## EL PASO COUNTY GRADING AND EROSION CONTROL PLAN CHECKLIST

EPC Project Number: SF254

C2.2 MVE PROJECT 61223
MVE DRAWING GEC-EC

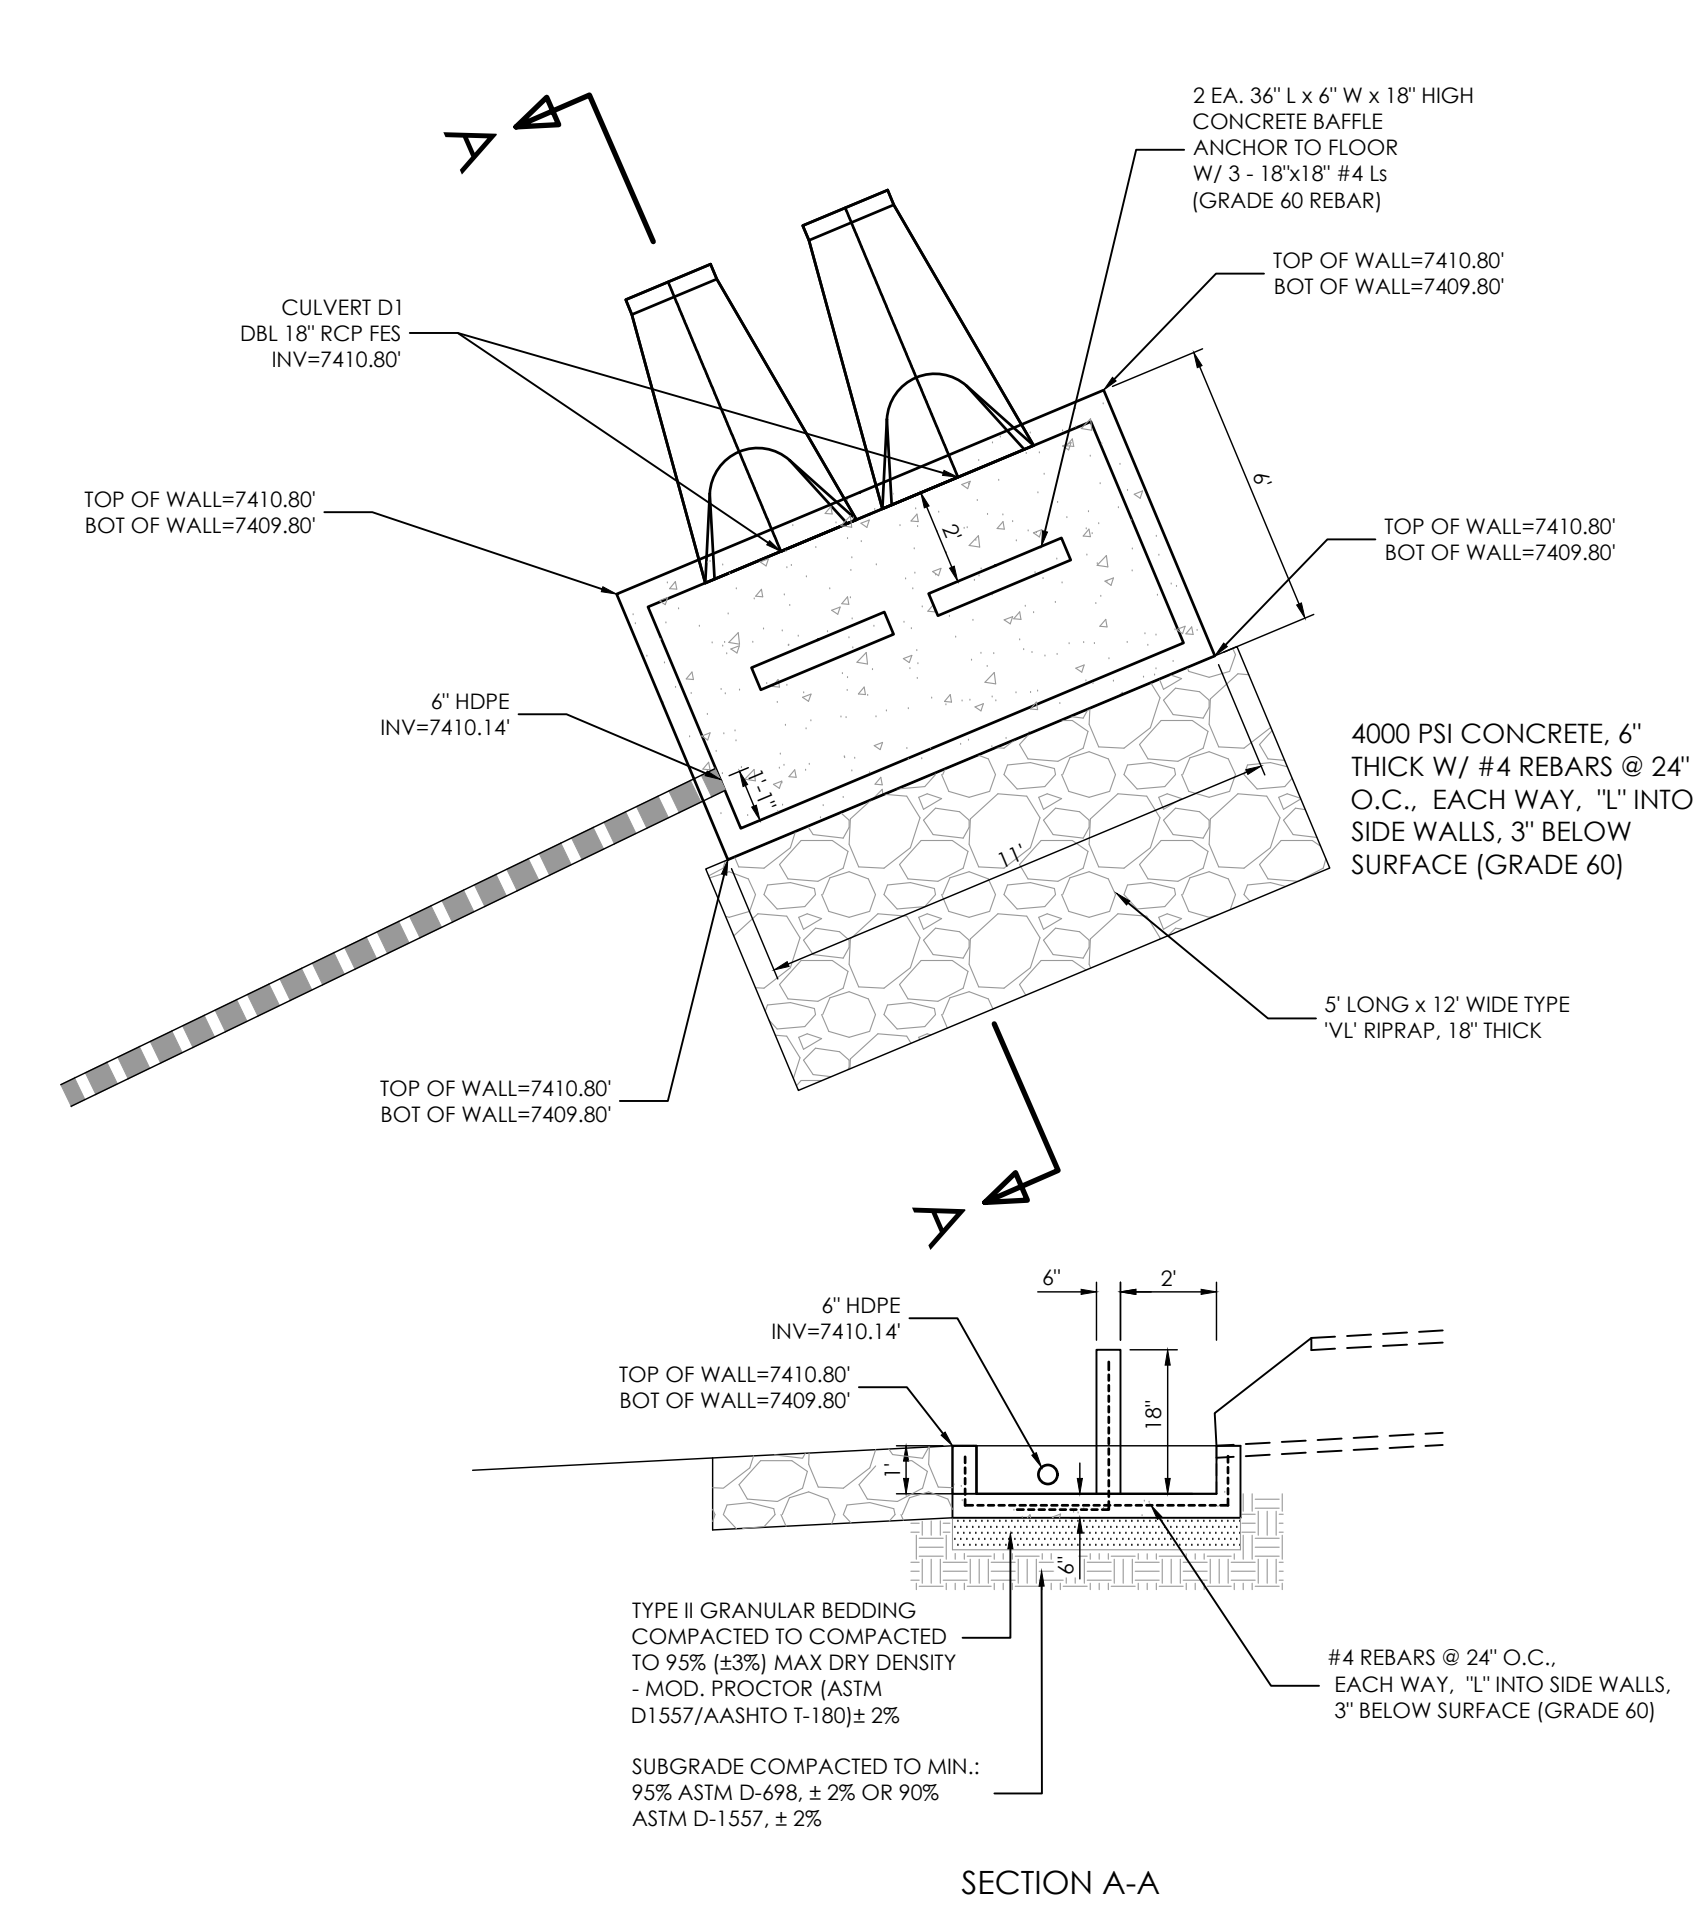
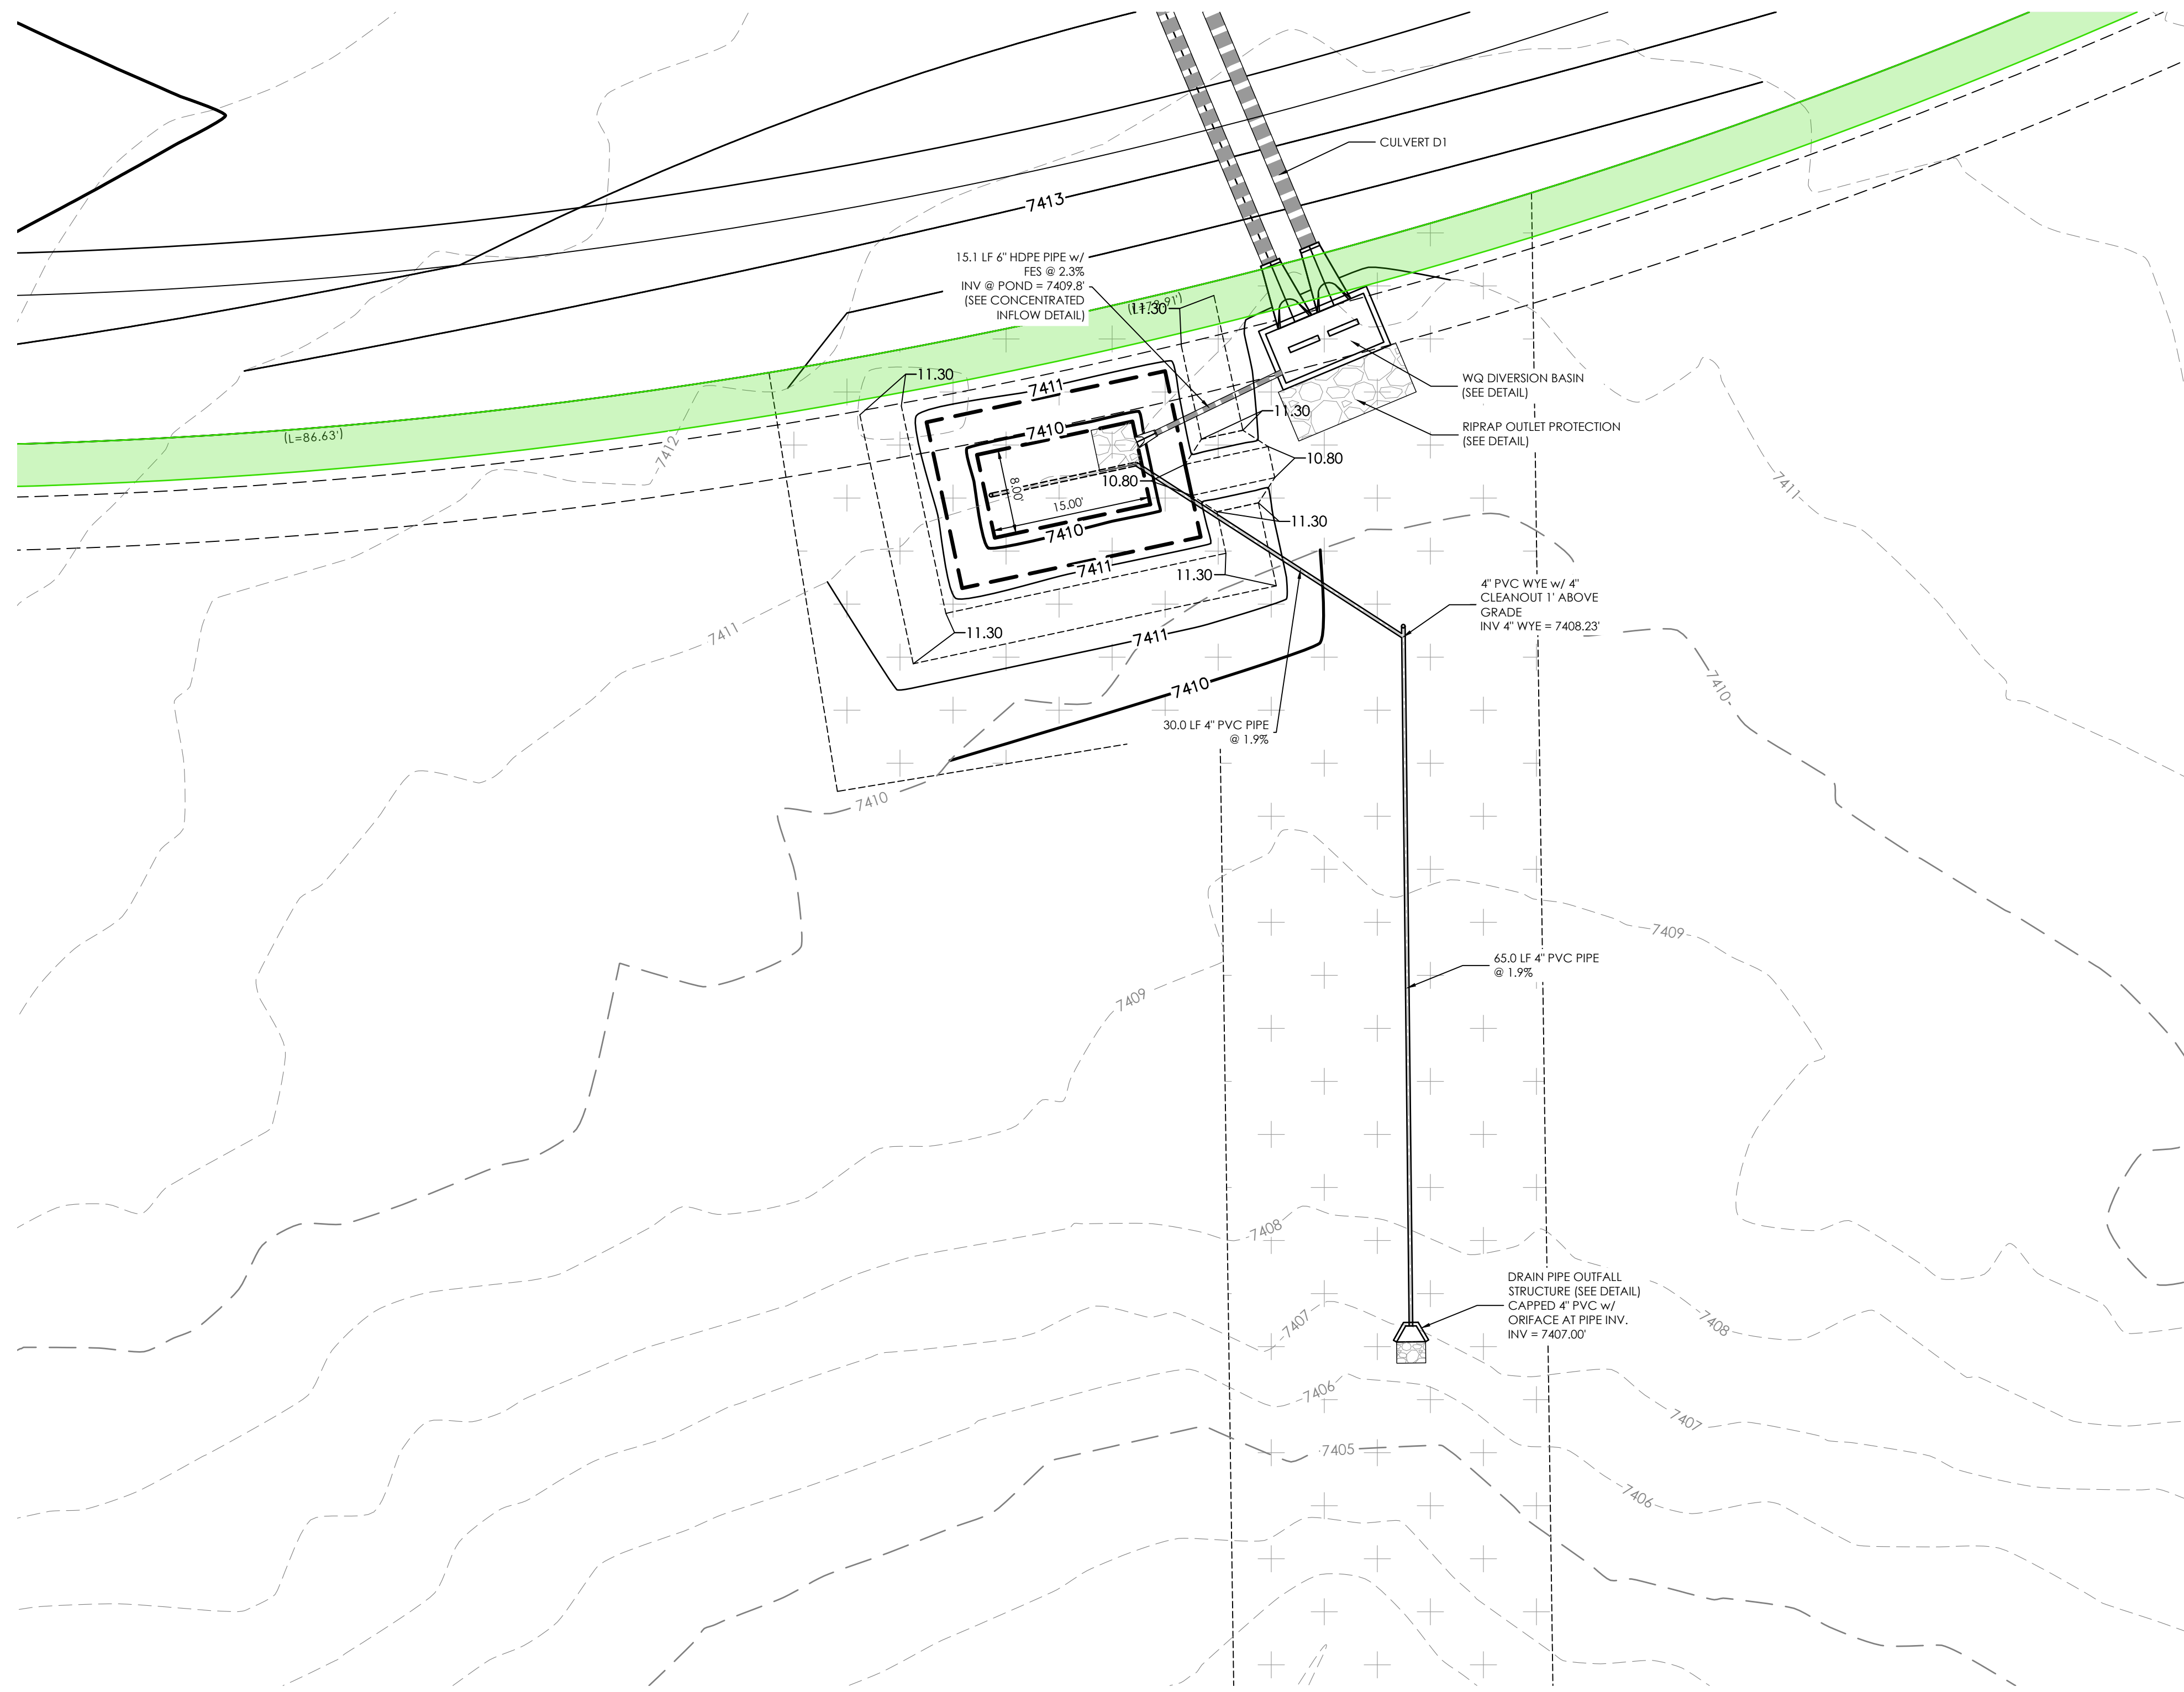
l	Existing and proposed contours 2 feet or less (except for hillside) <span style="border: 1px solid black; padding: 2px;">show contour labels</span>		N
m	Limits of disturbance delineating all anticipated areas of soil disturbance		Y
n	Identify and protect areas outside of the construction site boundary with existing fencing, construction fencing or other methods as appropriate		Y
o	Off-site grading clearly shown and called out		Y
p	Areas of cut and fill identified		Y
q	Conclusions from soils/geotechnical report and geologic hazards report incorporated in grading design (slopes, embankments, materials, mitigation, etc.)		Y
r	Proposed slopes steeper than 3:1 with top and toe of slope delineated. Erosion control blanketing or other protective covering required		Y
s	Stormwater flow direction arrows		Y
t	Location of any dedicated asphalt / concrete batch plants		N/A
u	Areas used for staging, storage of building materials, soils (stockpiles) or wastes. The use of construction office trailers requires PCD permitting		Y
